From: [Barnard, Megan](#)
To: [Aquind Interconnector](#)
Cc: [Maguire, Ian](#); [Williams, David](#); [Samuels, Tristan](#)
Subject: AQUIND - Portsmouth City Council - Deadline 3 Submission
Date: 03 November 2020 23:58:56
Attachments: [20201027 EN020022 AQUIND - Rule 17 to the Applicant and Portsmouth City Council.pdf](#)
[20201103 Rule 17 response to ExA re Allotments.pdf](#)
[Appendix A - Plan showing allotments affected \(not definitive\).pdf](#)
[Appendix B - Allotment Tenancy Agreement Form until 2019.pdf](#)
[Appendix C - Allotment rules, Jan 2019 v5.pdf](#)
[Appendix D - Pro-forma Allotment Invoice.pdf](#)
[Appendix E - Allotment Offer Letter Under simplified letting process, 2019 onwards.pdf](#)
[20201103 PCC Letter to PI re Deadline 3 Final.pdf](#)

Our Ref: 20201103

RE: Deadline 3 Submission in respect of the Application by AQUIND Limited for an Order granting Development Consent for the AQUIND Interconnector Project.

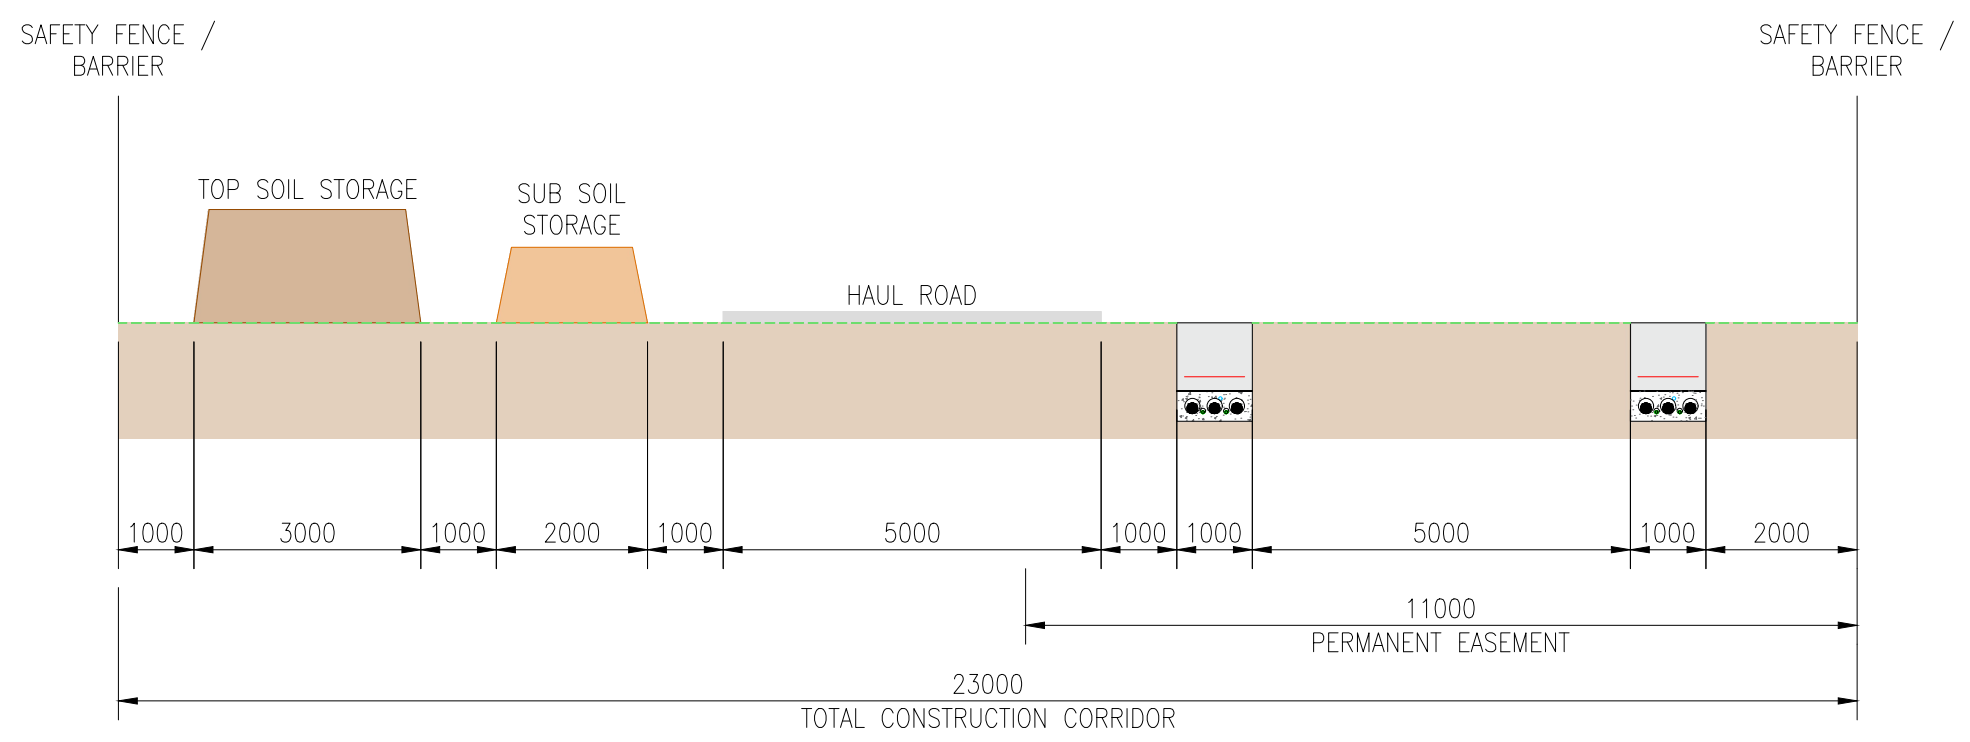
5.12- With regard to subsoil highway works, the applicant's position seems to be that the land below that depth necessary to support / drain the highway does not form a part of the highway and therefore needs to be acquired in order to install the equipment lawfully. The installation cross sections indicate the cable installation at an average depth of 1m. The highway drainage infrastructure is generally significantly deeper than 1m below the surface (typically between 2 and 3m) and as a consequence the installation is in fact intended within the highway with no need for further compulsory acquisition. To be clear the extent of the highway does not 'stop' when physical elements of the highway are lower than the 'top 2 spits'. Any alternative interpretation must find that the equipment of all other statutory utilities has been installed beyond the highway limits unlawfully.
